Your Ref: SSD-5916

Proposal: Raphael Shin Enterprises Pty Ltd v Minister – The Bay Resort, Anna Bay (SSD-5916) - Land and Environment Court Proceedings No 2020/328548 – Amended Environmental Impact - Statement
Property: 4177 Nelson Bay Road, Anna Bay - Lot 2 DP 747399

SUSPENDED ROAD - TYPICAL SECTION
SECTION A C04.13

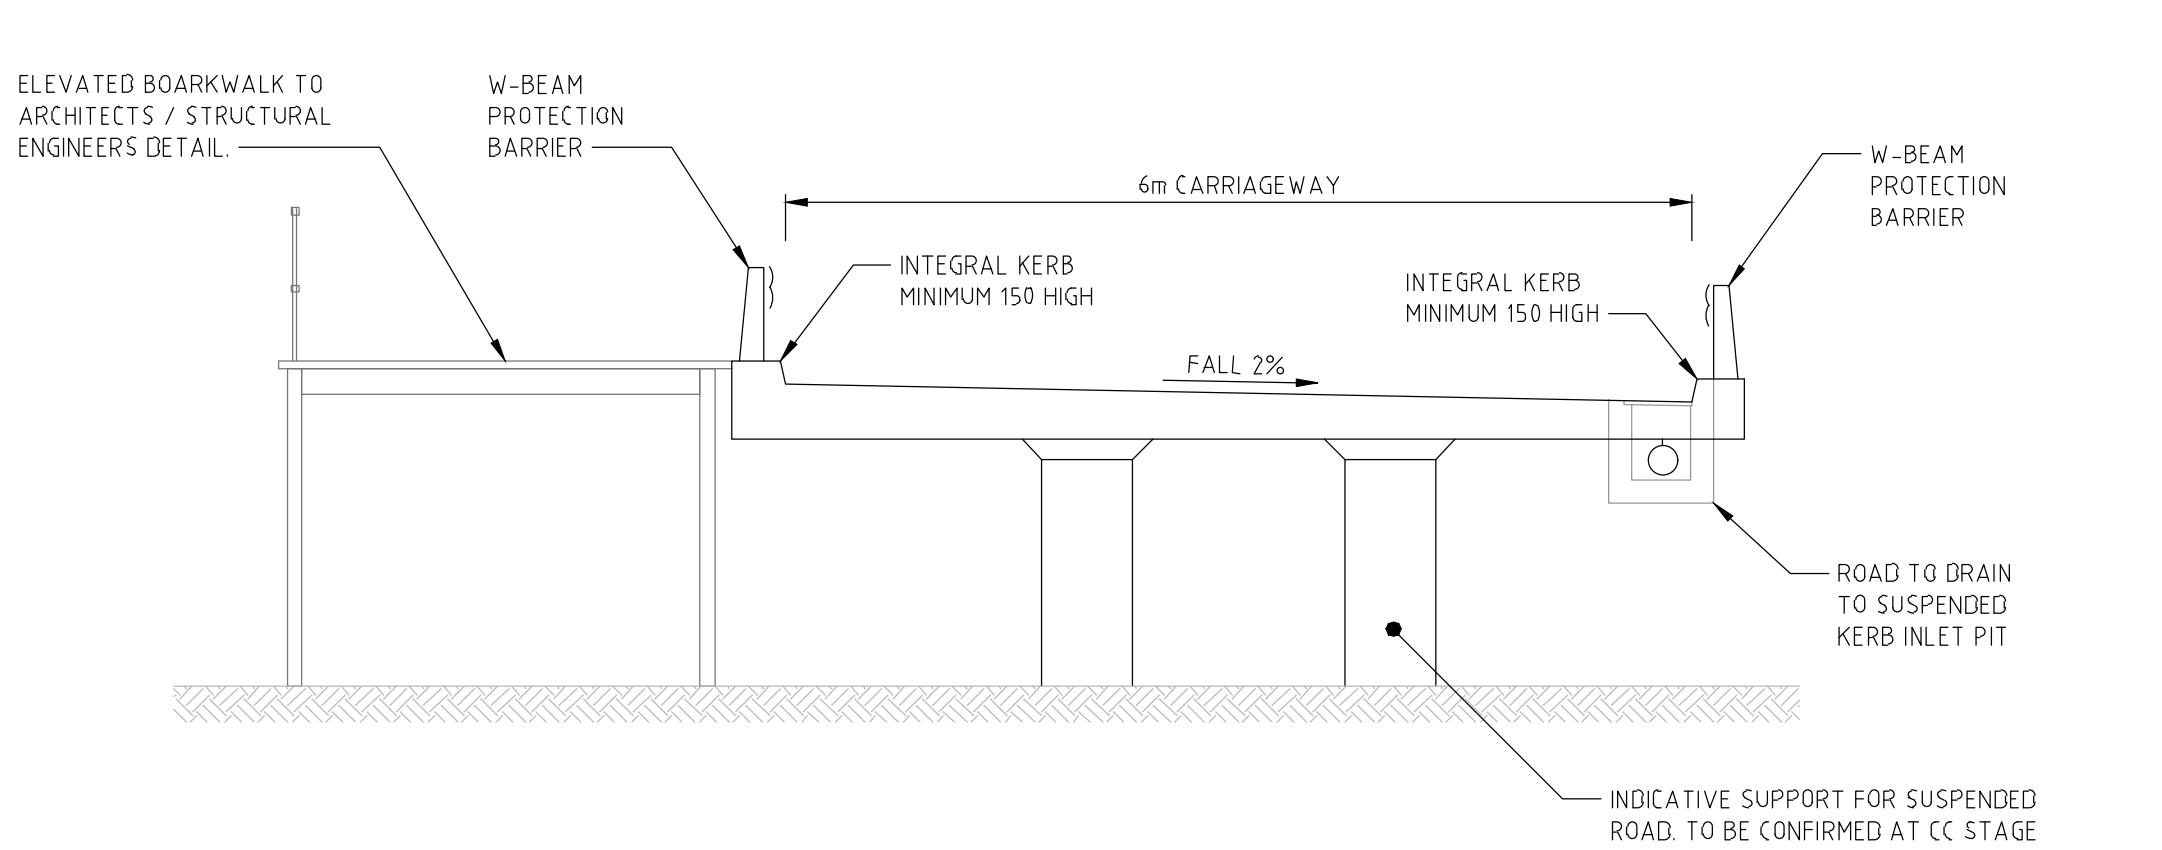
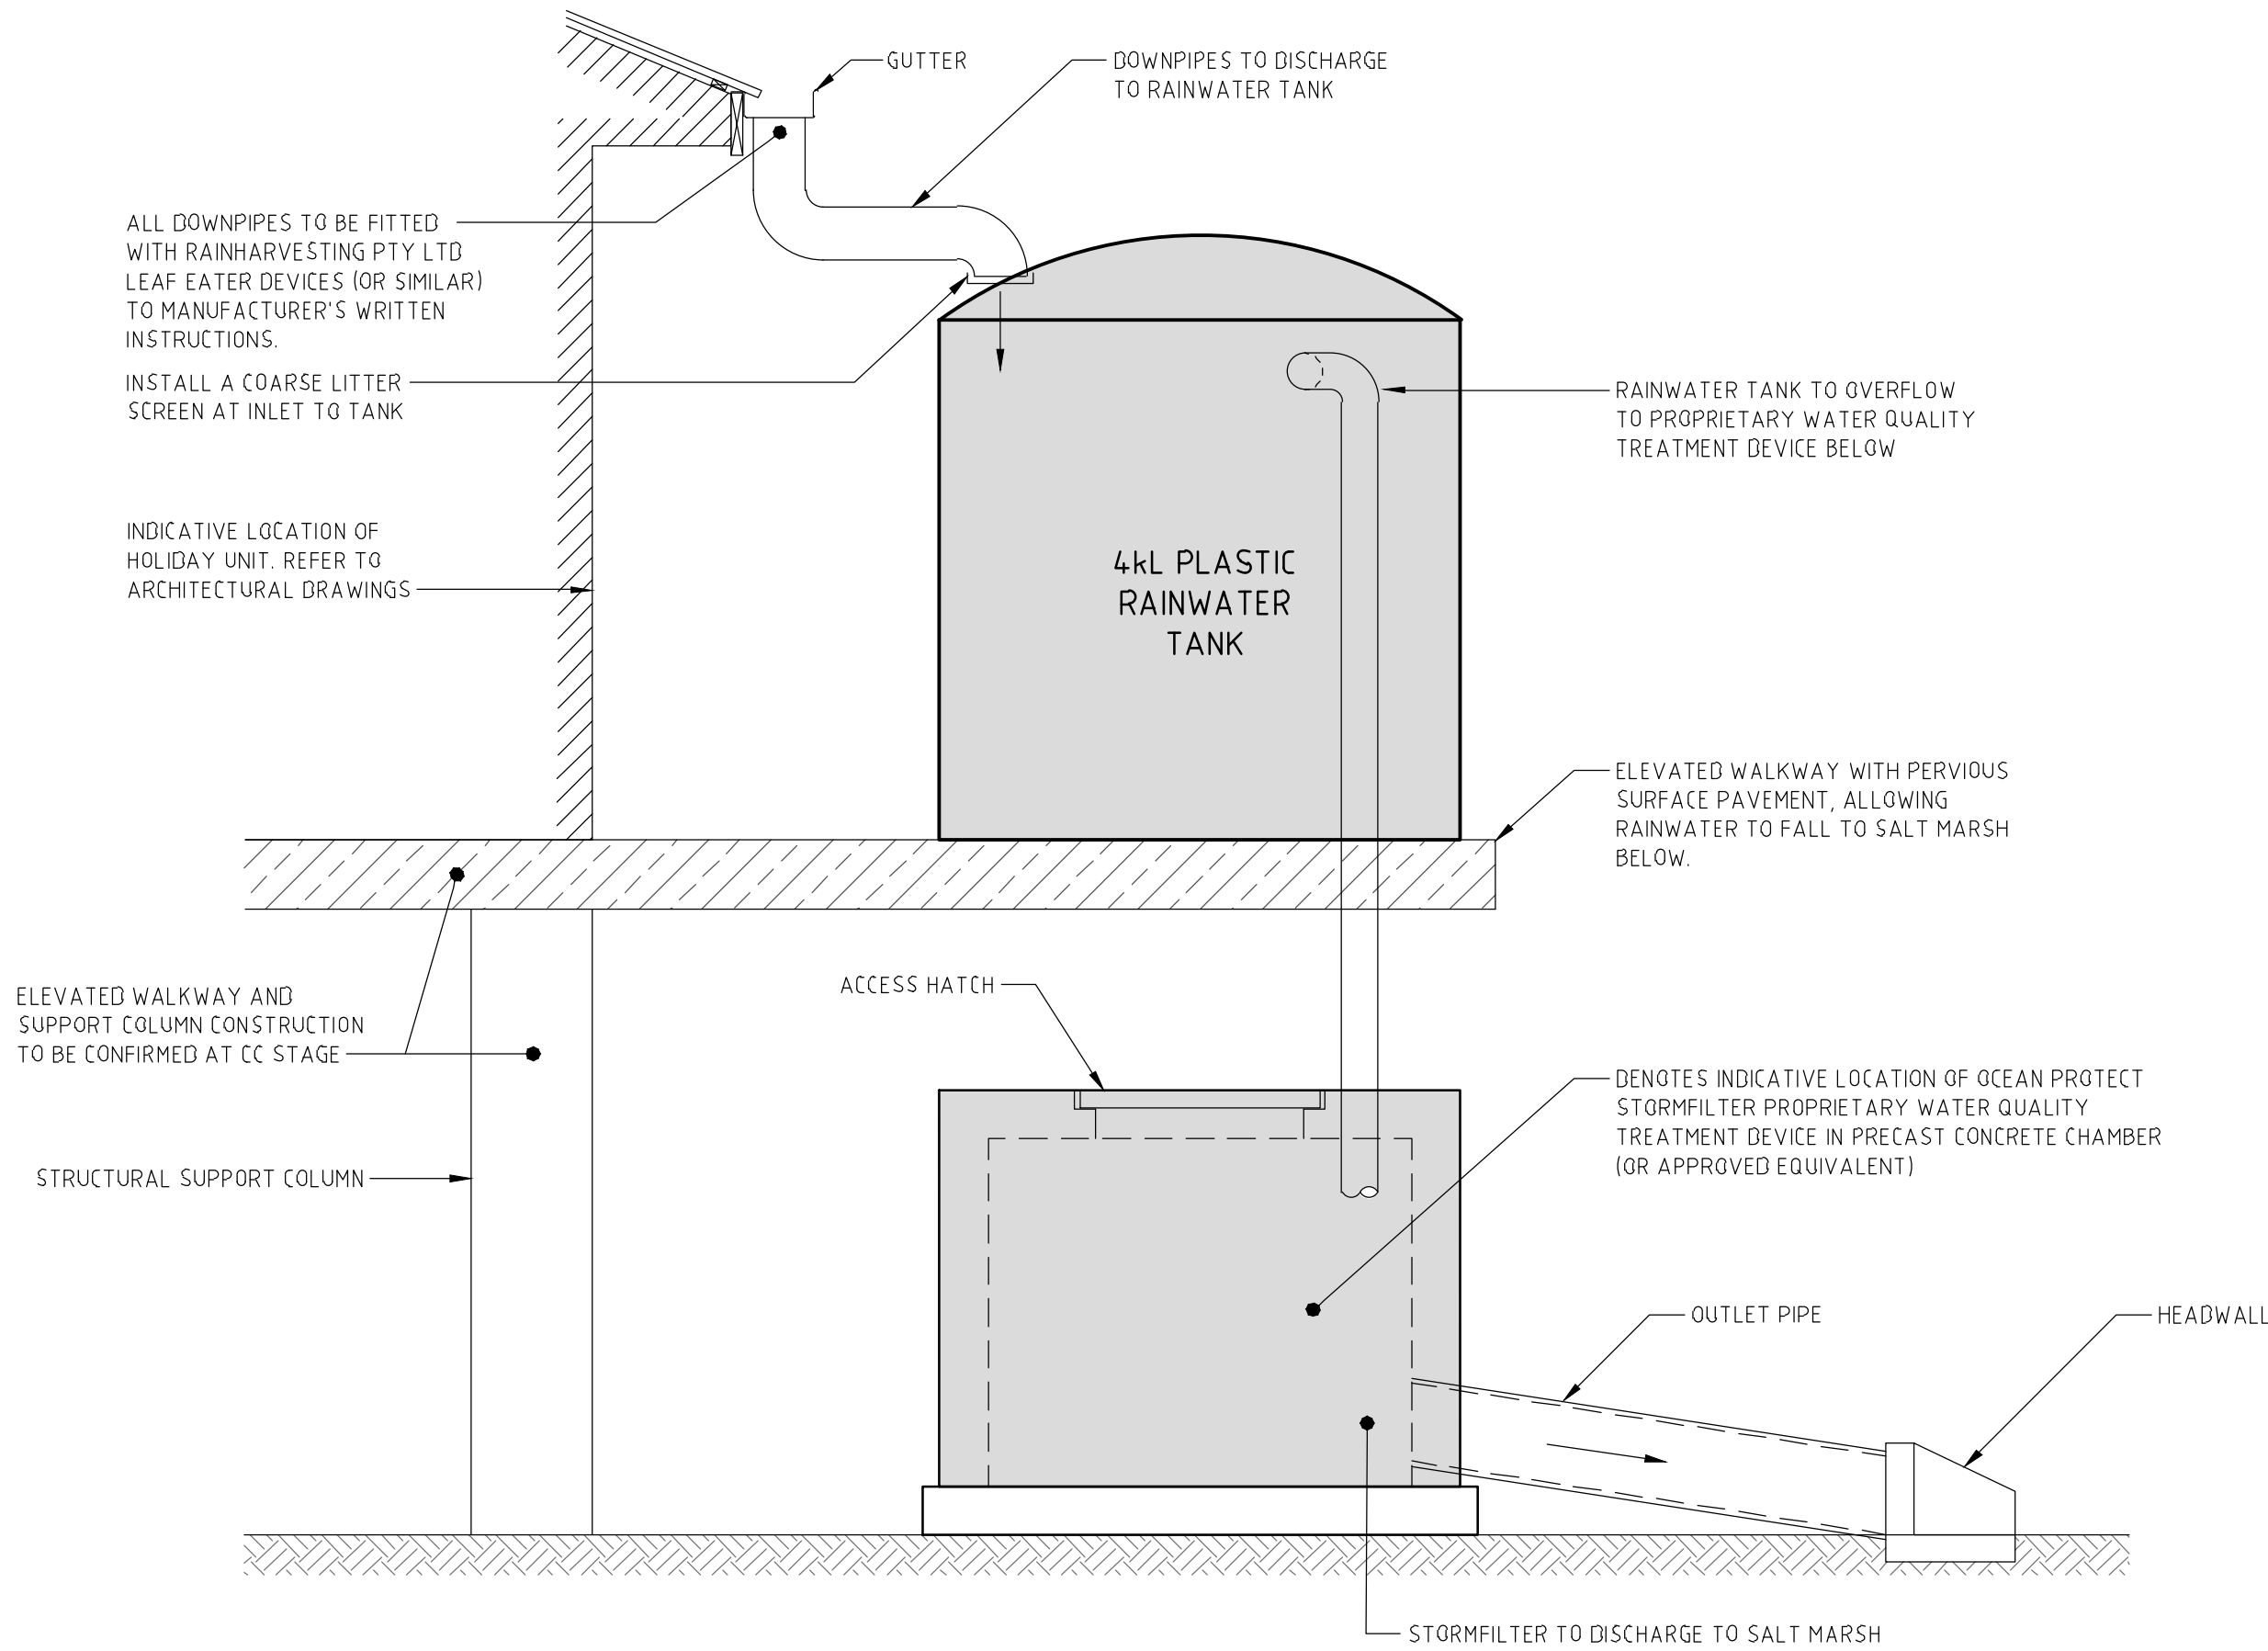
The installation of the service roads and boardwalks need to be constructed in a manner that does not cause either ponding or create concentrated flows on the site
